Planning Application 3/2023/1011

41-43 Wellgate
Cuthbert

I would like to comment on the proposal to create five apartments at the above address.

Title: Proposed Refuse Plan	Drawn: HA
Client: Wajid Mahmood	Checked:
Date: 1-12-2023	Paper: A3
Drawing No: HAD3858-10	Scale: 1:200
Revision:

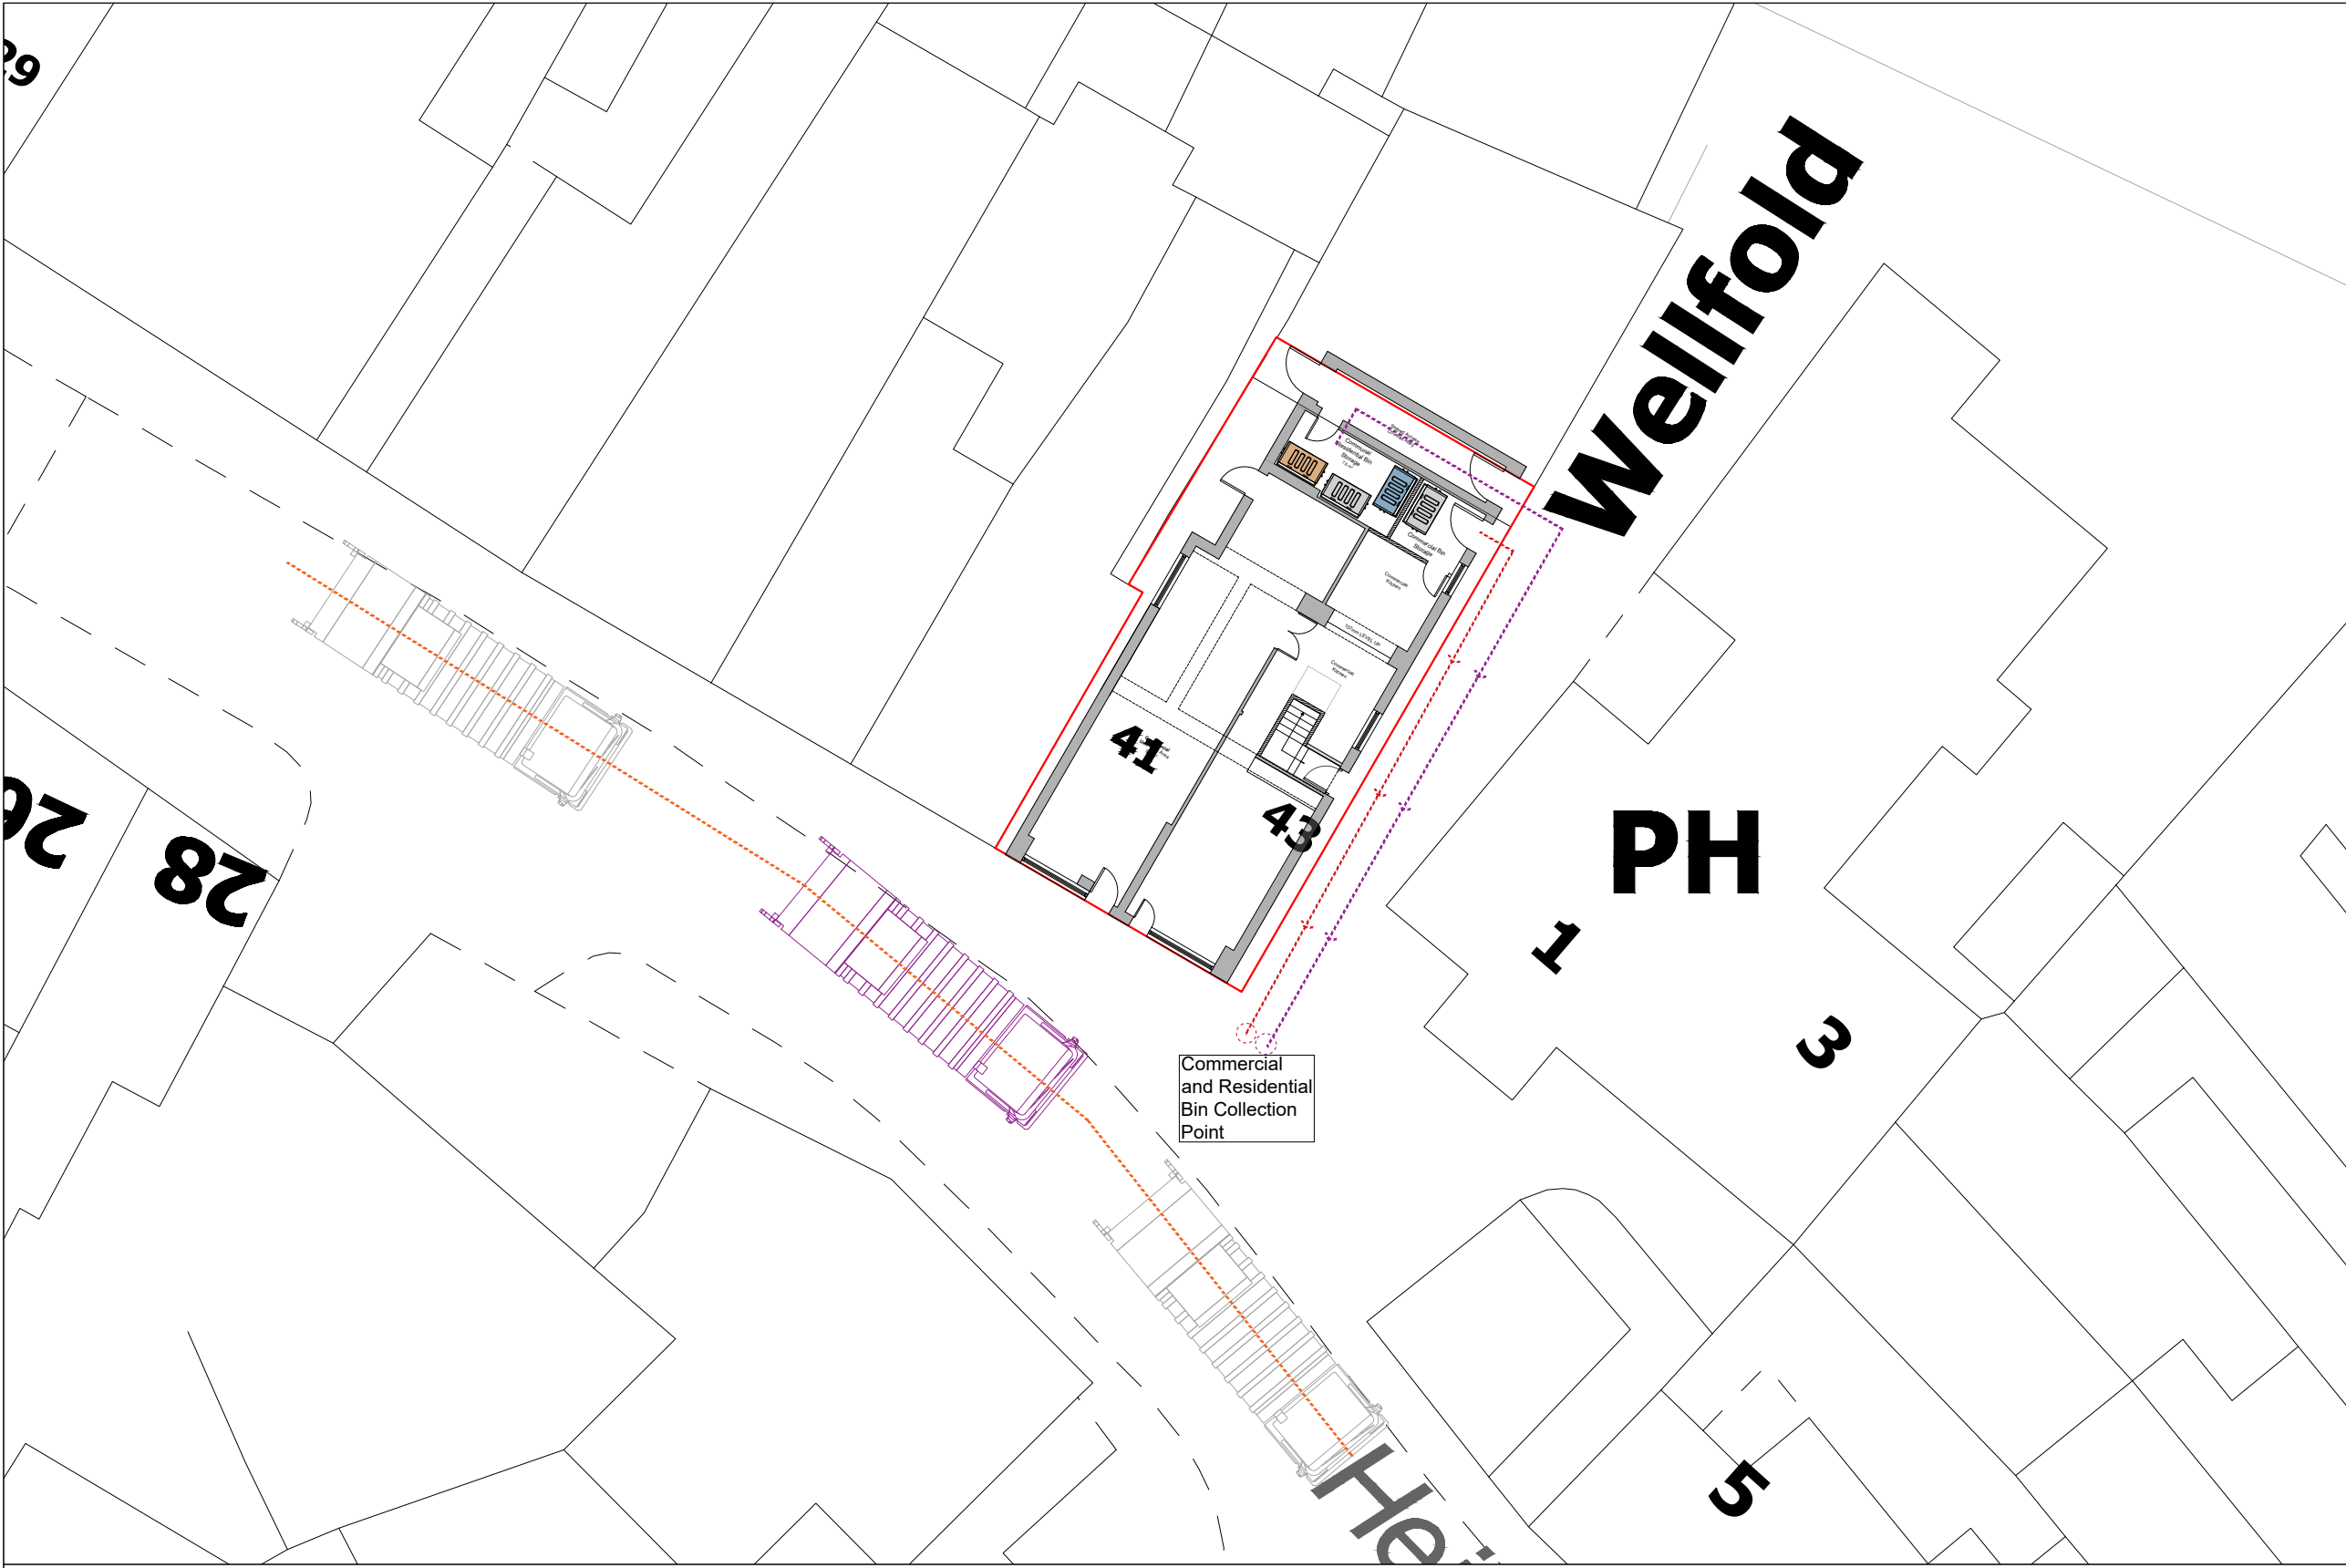
Five apartments at the site would seem excessive, the waste disposal arrangements look inadequate, and the parking arrangements not existent.
